# Comment Response Memo

1 March 2023

Strand Residence – 2207-019

6950 Maker St

SHORING PLAN
 SCALE: 1/4" = 1'-0"

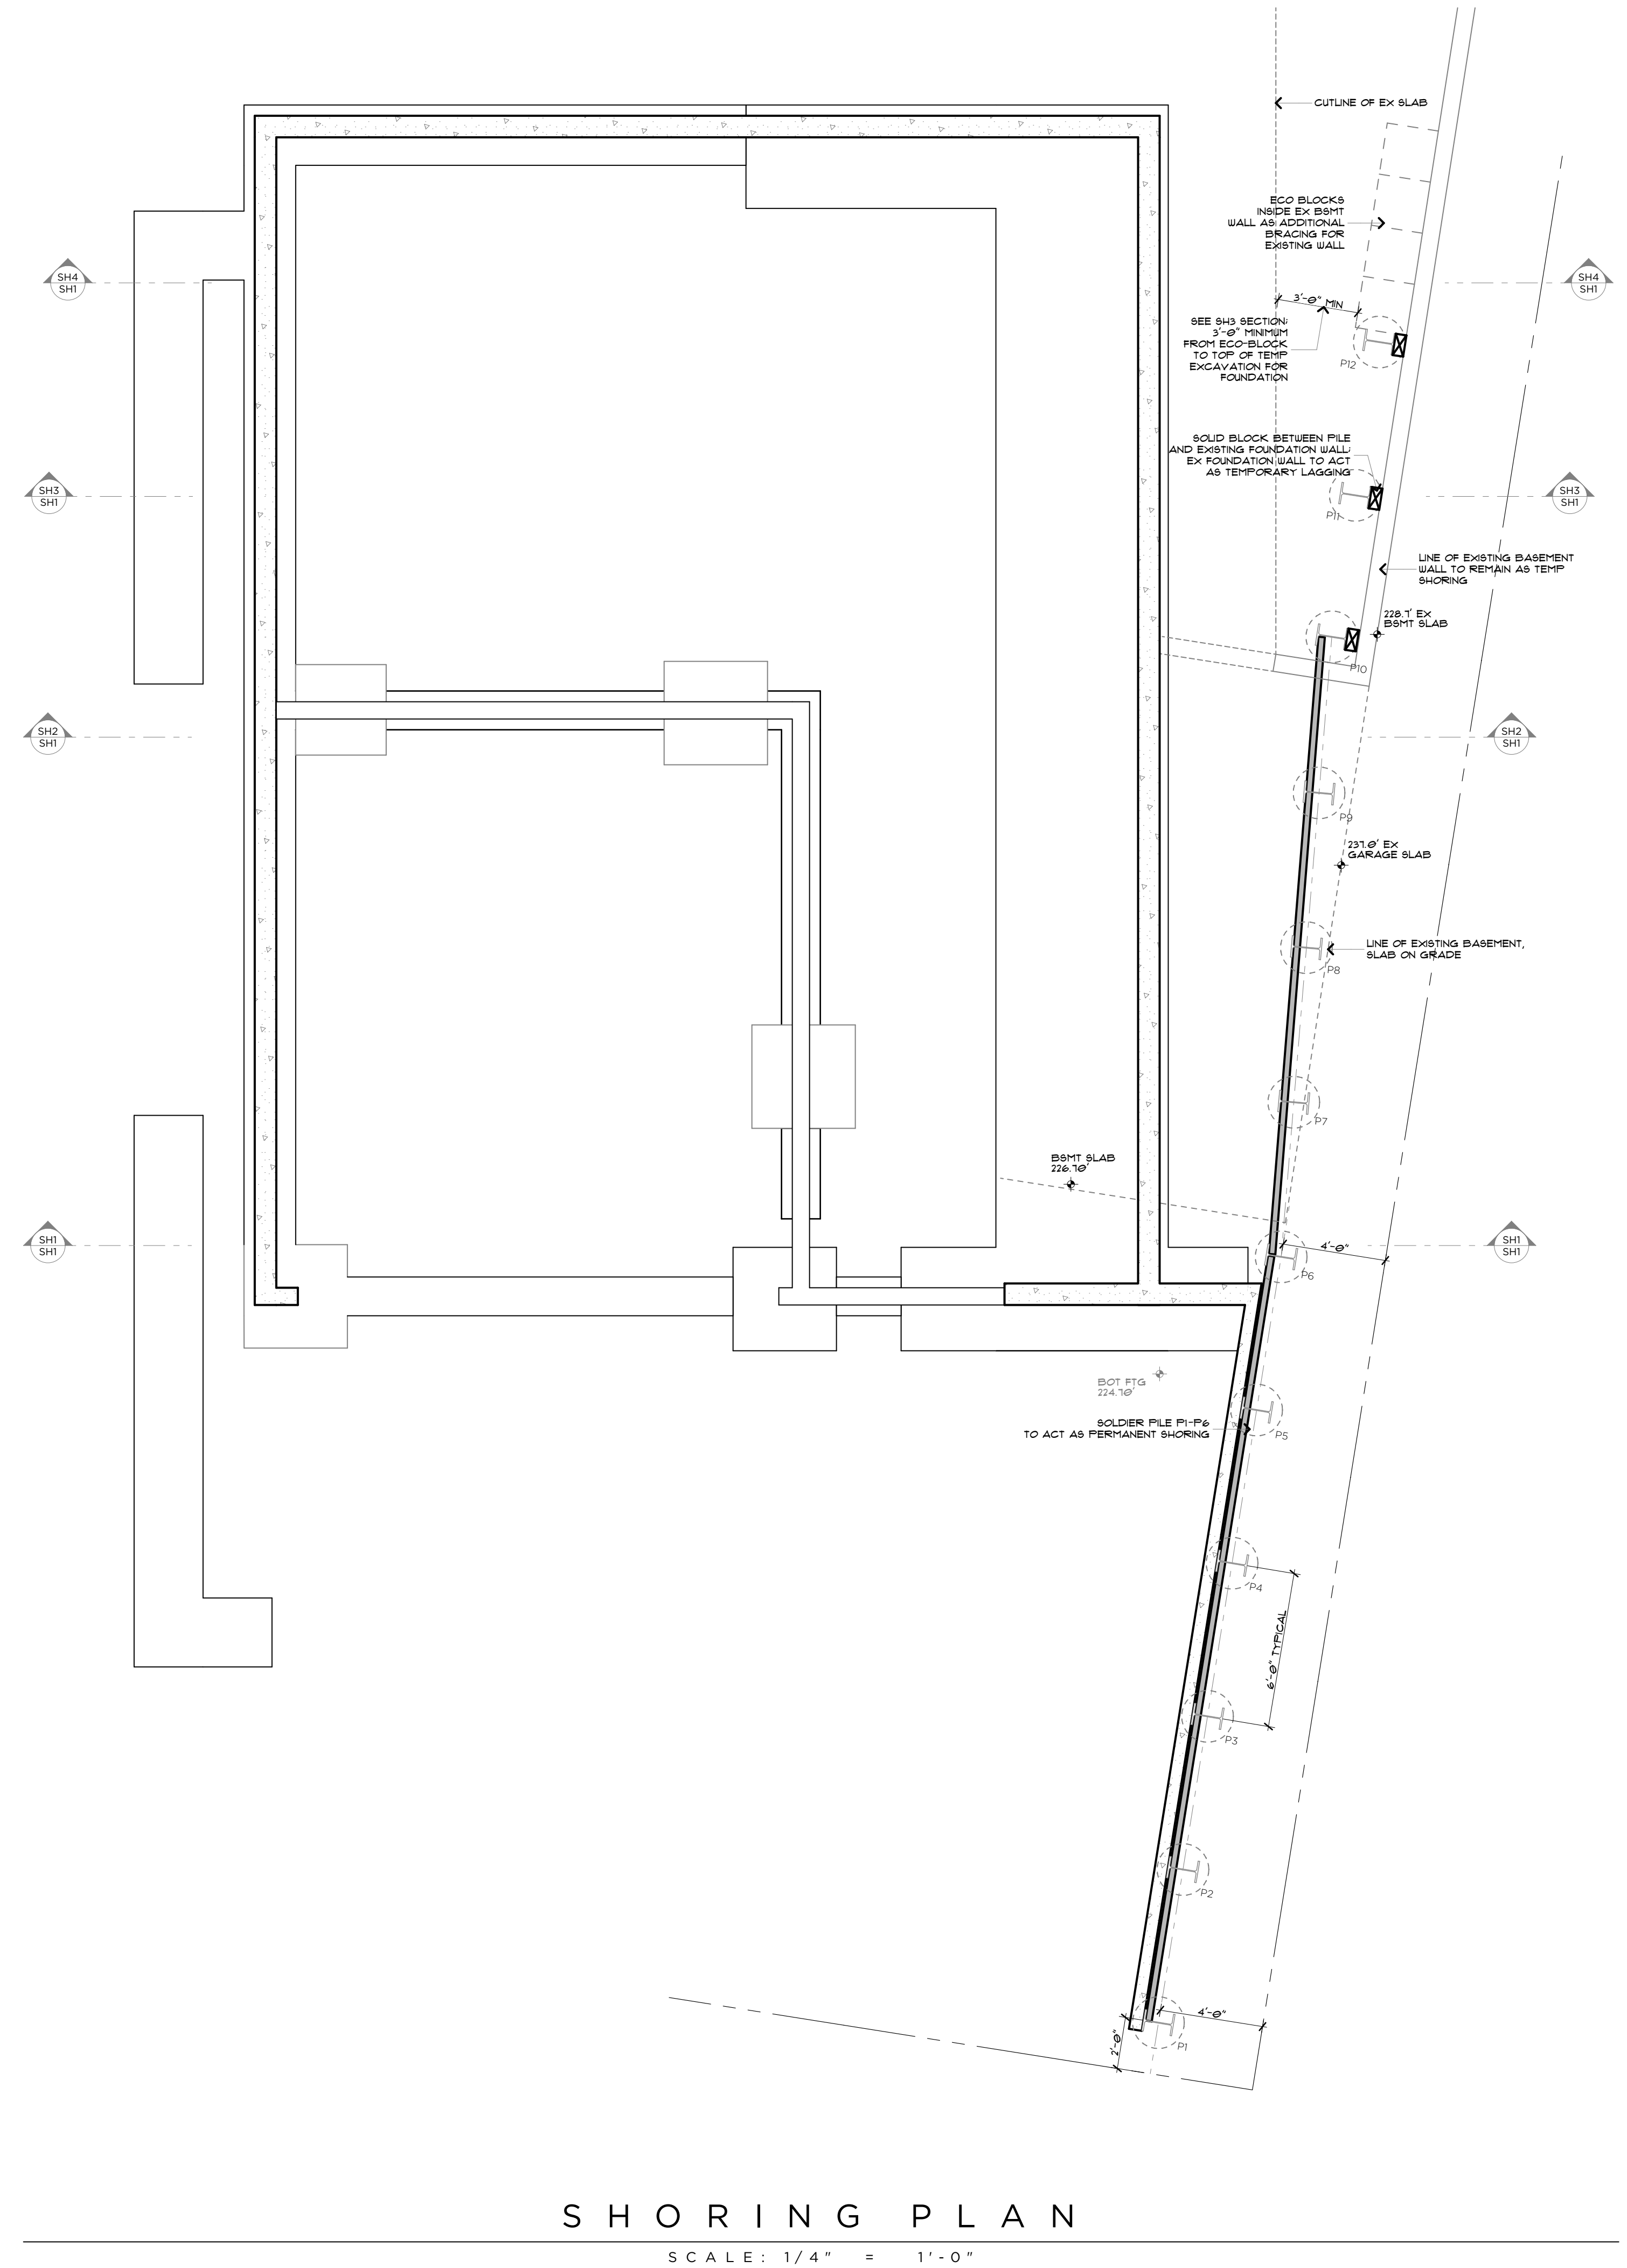
2. The proposed project after revisions in response to comments has been reviewed by Geotech Consultants and they have provided a Statement of Risk regarding the proposed development. Temporary shoring is included in the updated permit submittal and takes into account bracing the neighboring rockery to the East.

BASEMENT PLAN

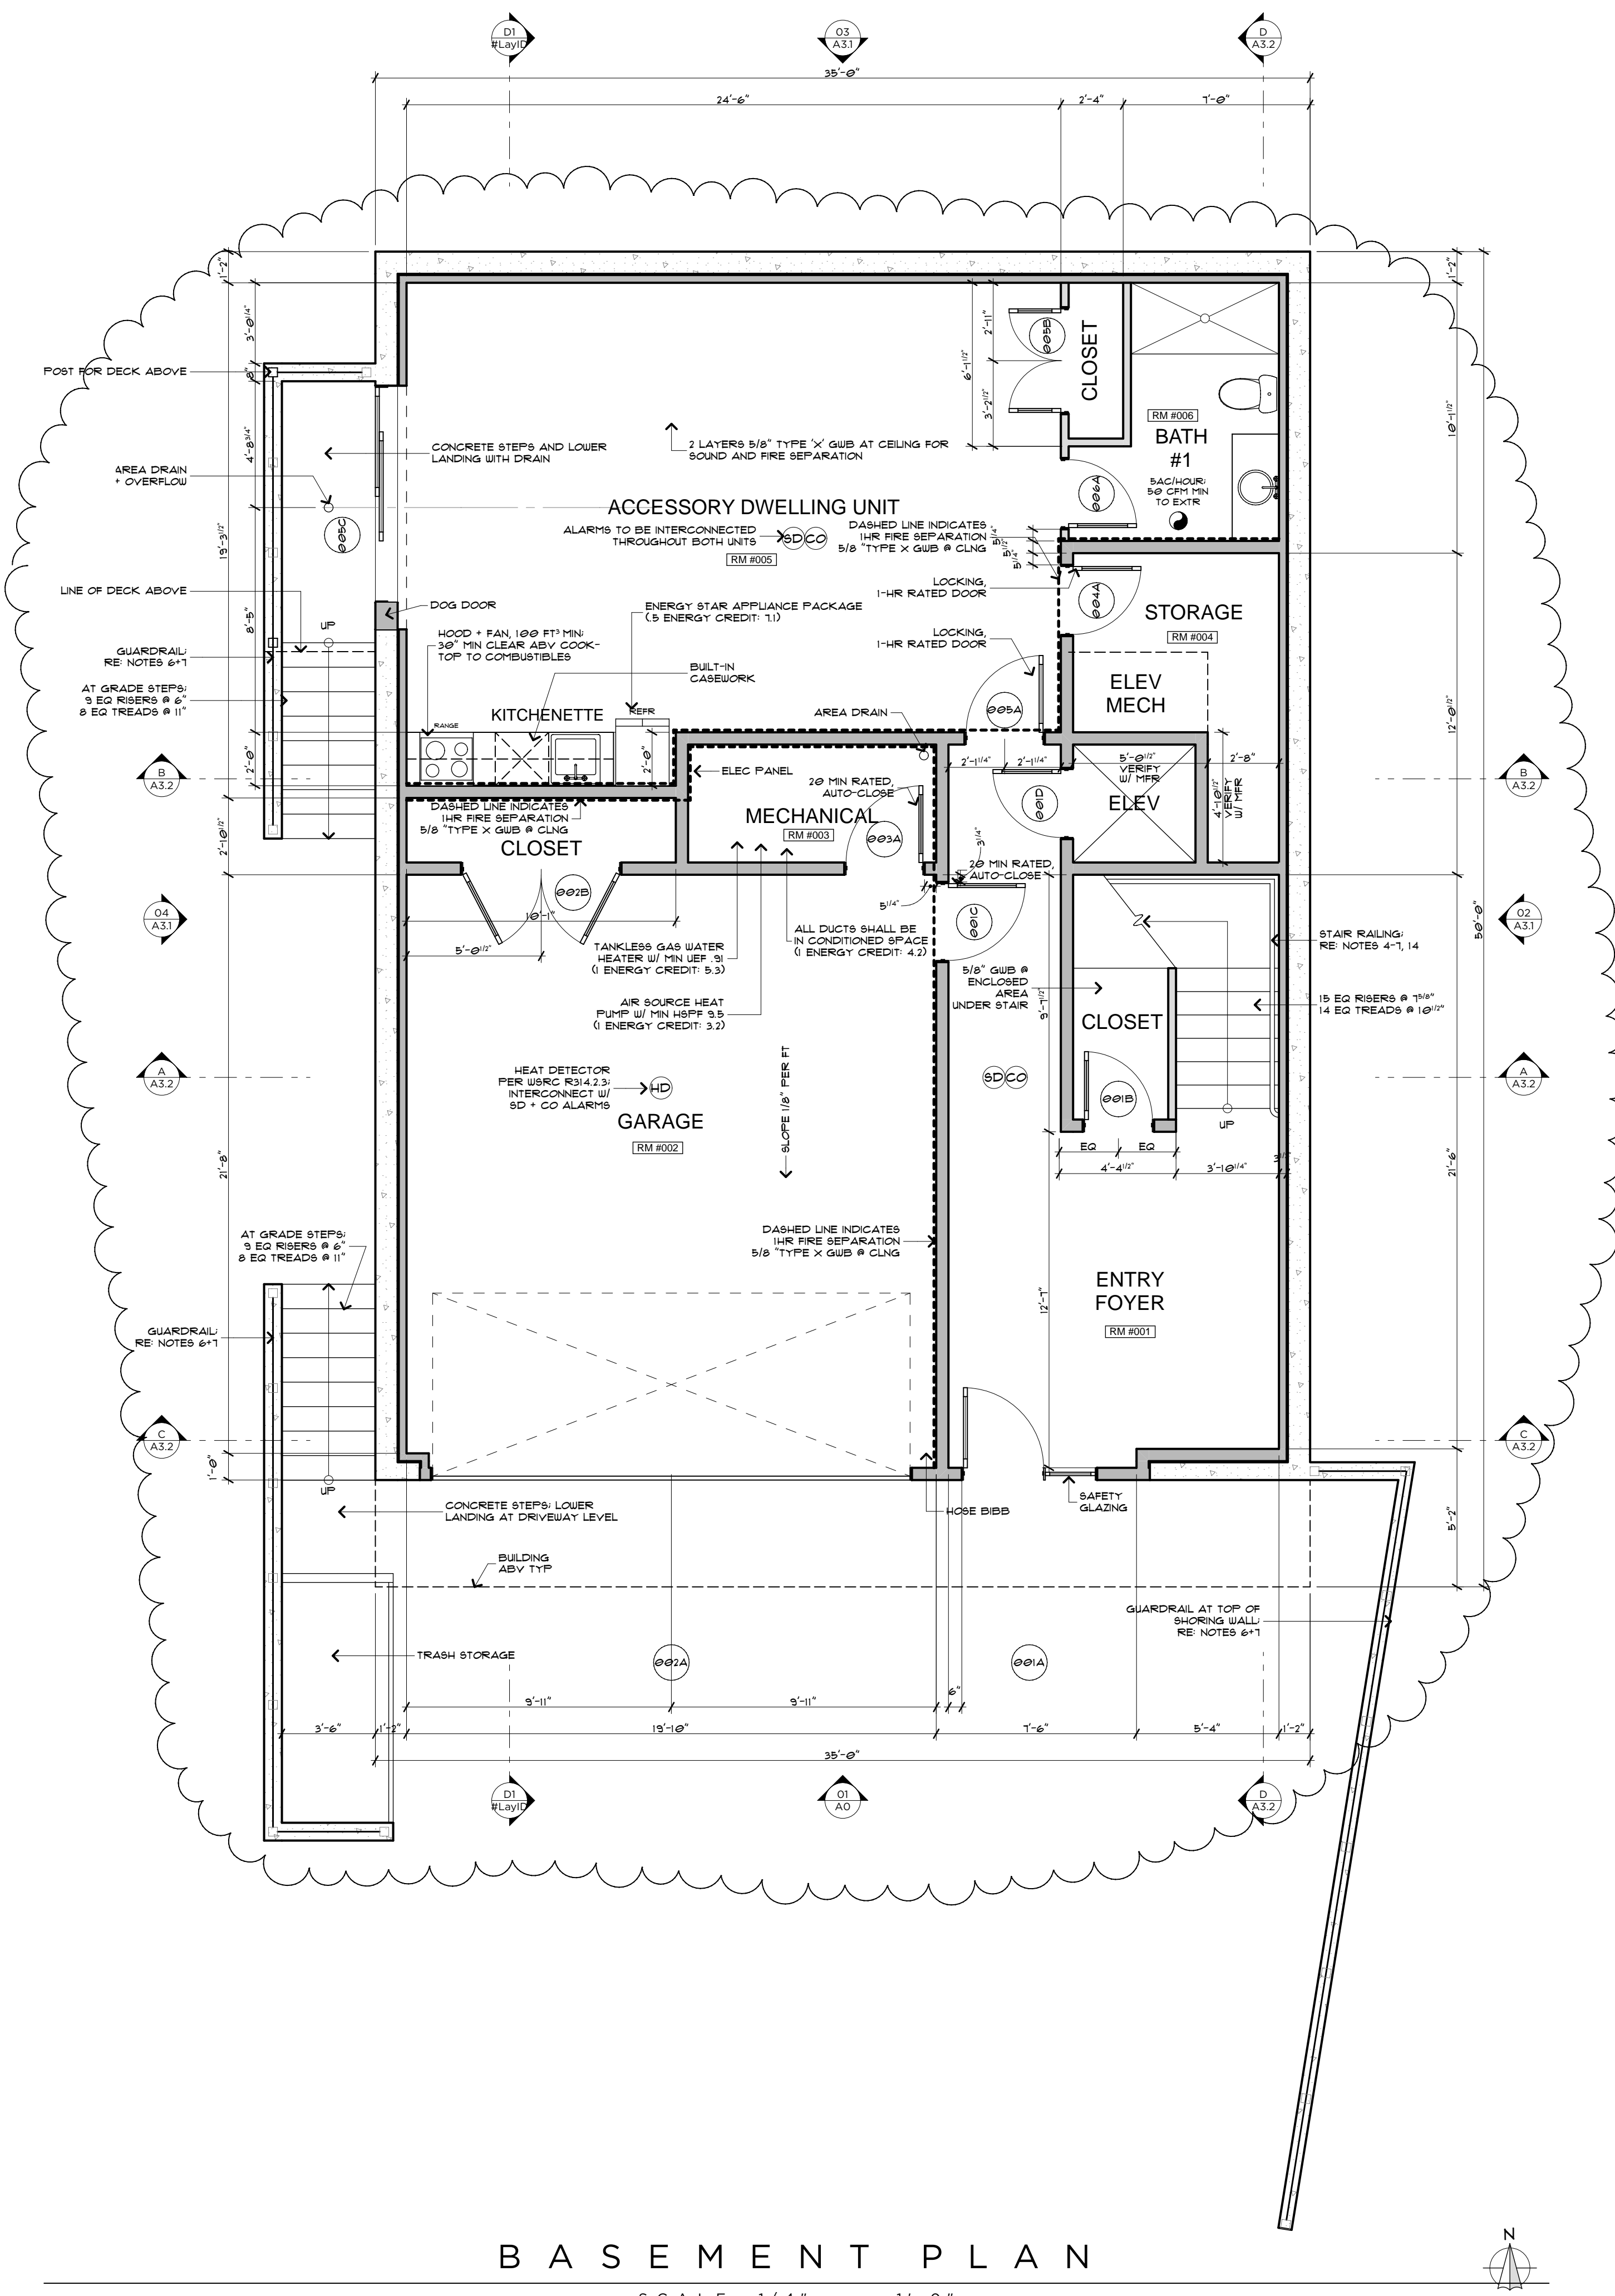
7. Regarding the letter from Jim and Susan Mattison – Gross Floor area calculations are supplied in the updated submittal documents and revisions to the project show compliance with Mercer Island Code regarding GFA and basement exclusion. As stated above we understand the accepted interpretation of existing grade to be the surveyed grade prior to the proposed development. Geotechnical concerns have been addressed in updated reports and Statement of Risk by Geotech Consultants. Stormwater management has been addressed in Civil Drawings by attaching to existing catch basins as shown in updated submittal documents. Similar to comment above regarding trees it is my understanding that John Kenney has reviewed and addressed concerns with vegetation and tree trimming as part of this permit review. In regards to parking and construction equipment and street access those concerns have been relayed to the contractor so that any impact to neighbors is addressed in advance. We have also asked the contractor to provide a CMP.
